# SETTLERS RANCH

## Filing No. 2C

# Construction Drawings

**PCD FILE NO. SF-18-018**

SHEET: PH1C

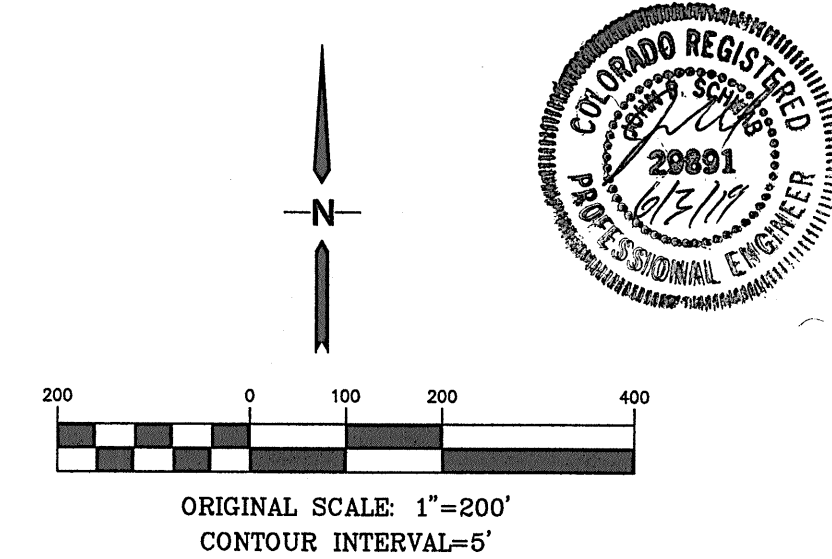
Reflect basic row width as a tract on plat so developer to north can connect-and improve roadway potentially.

SHEET: C1.02C

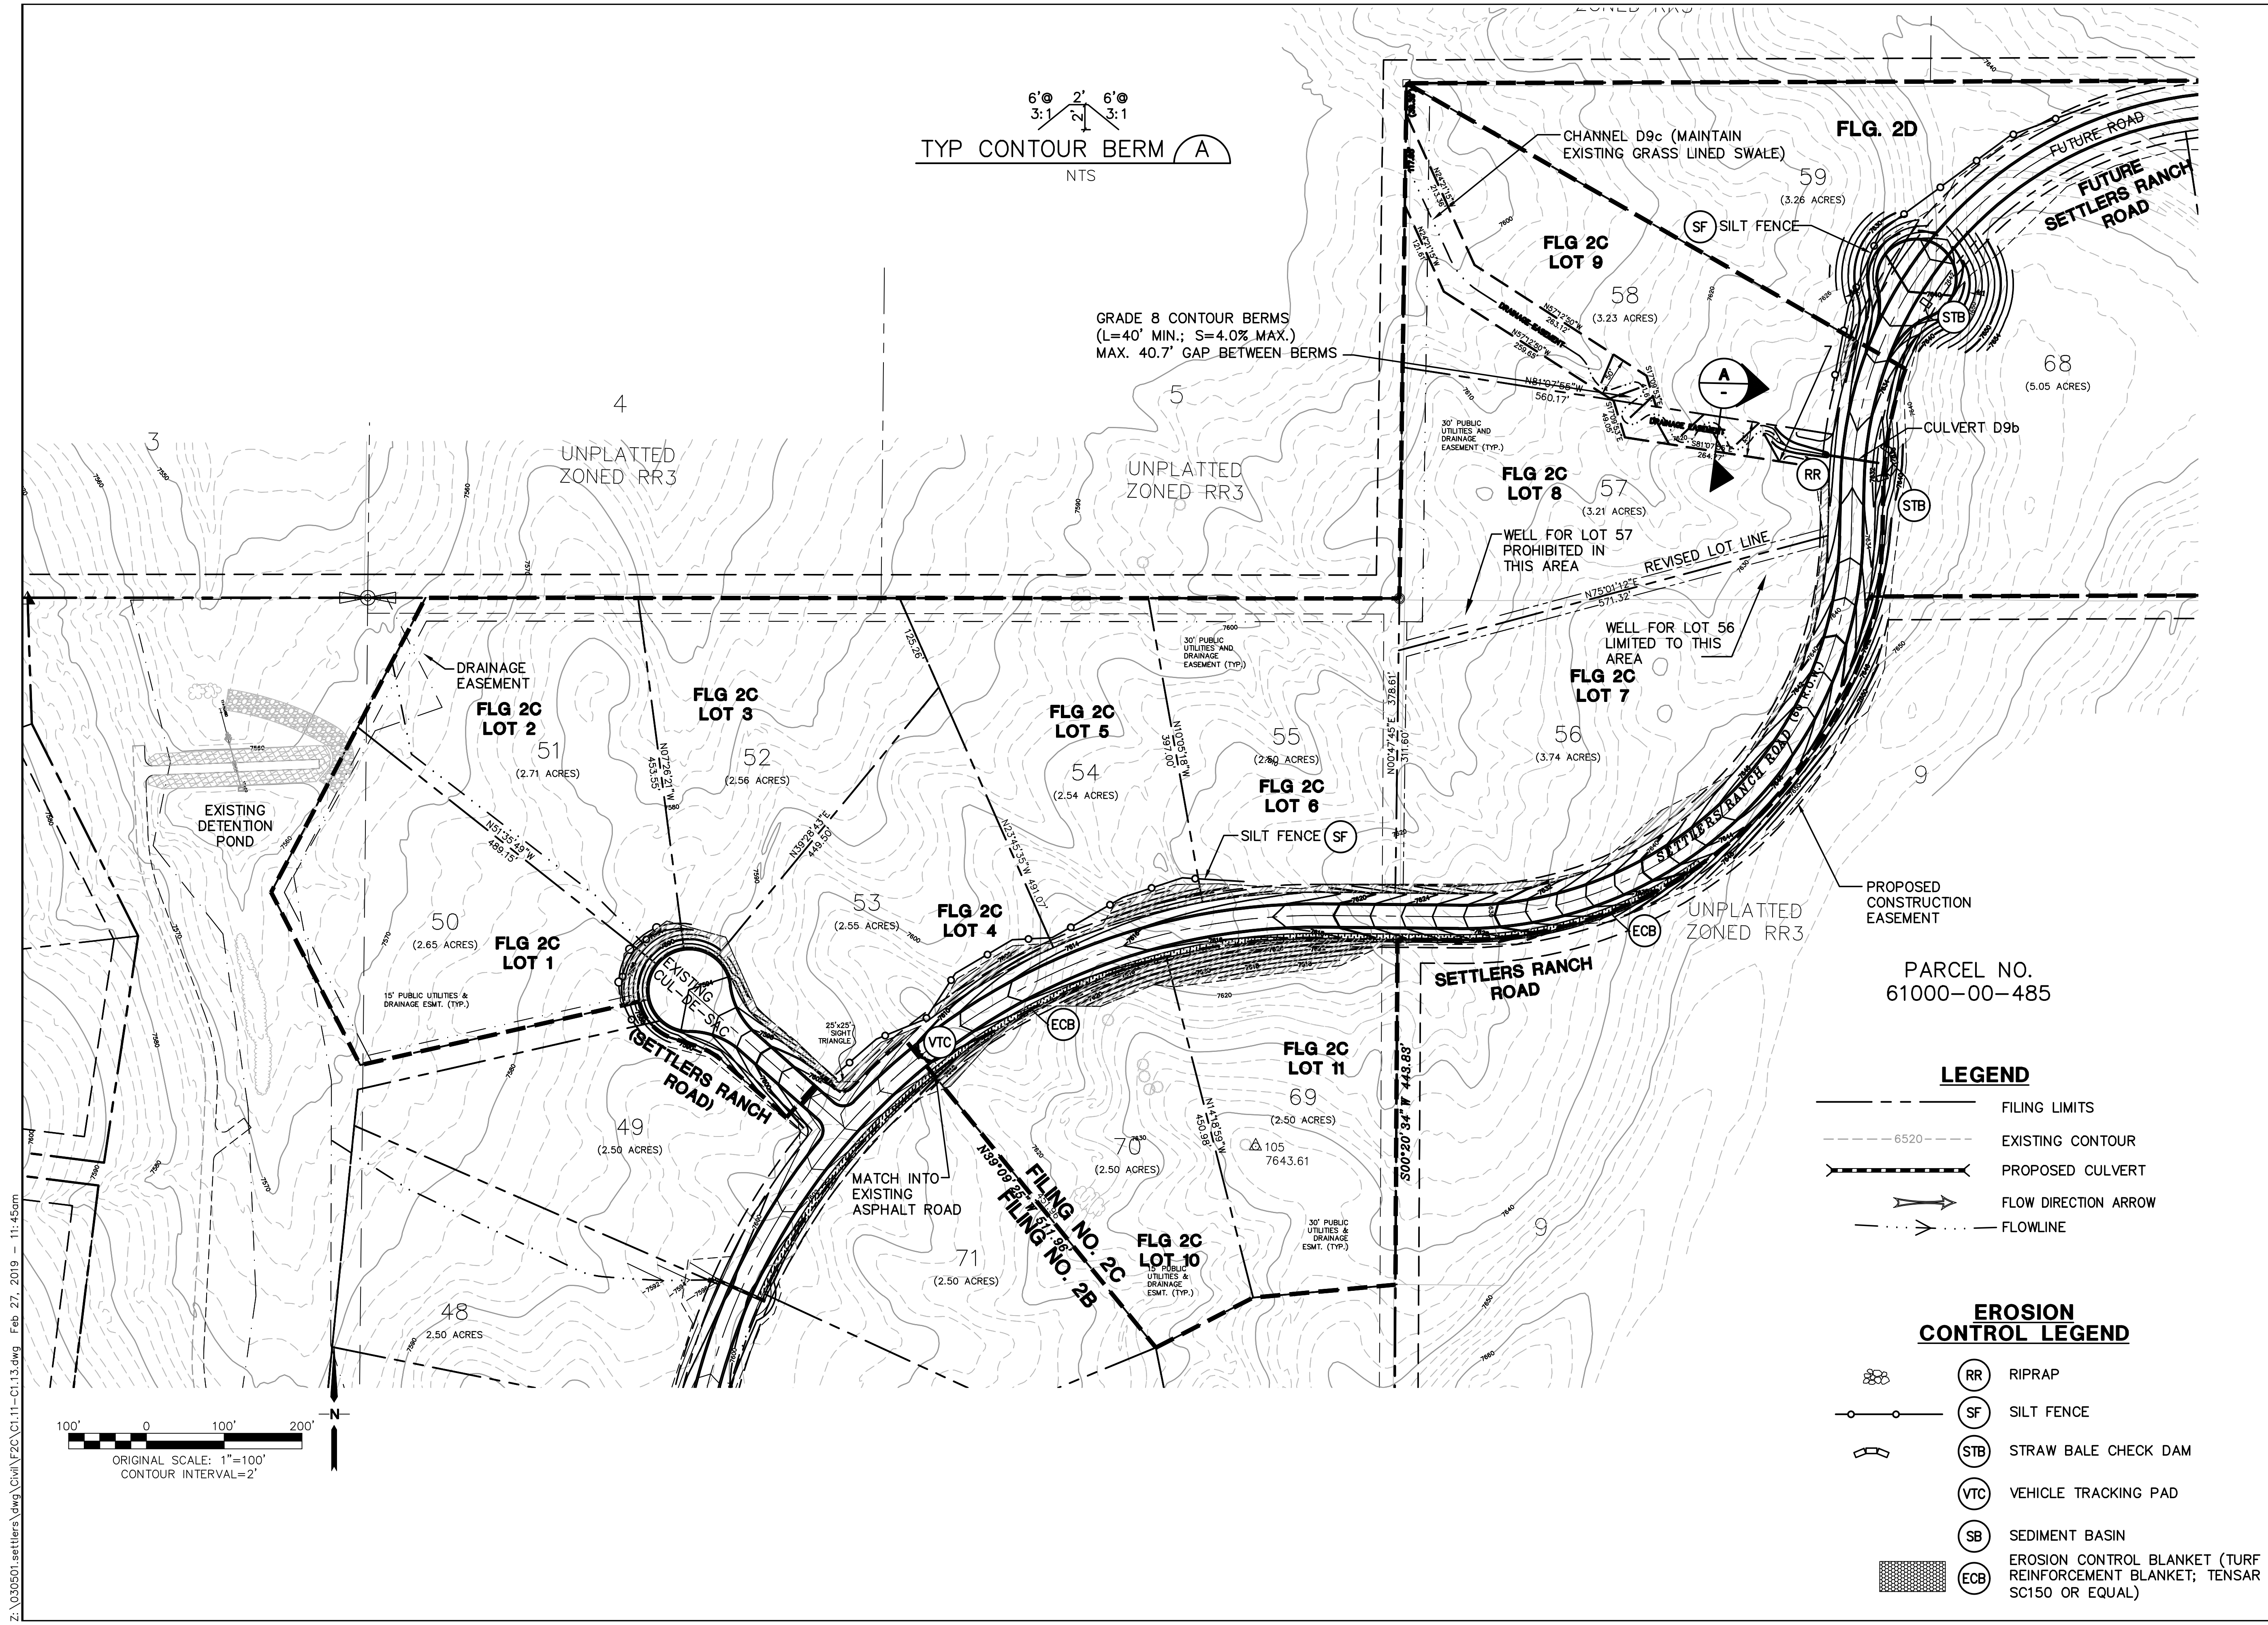
Show & label the drainage easement.  
Unresolved.
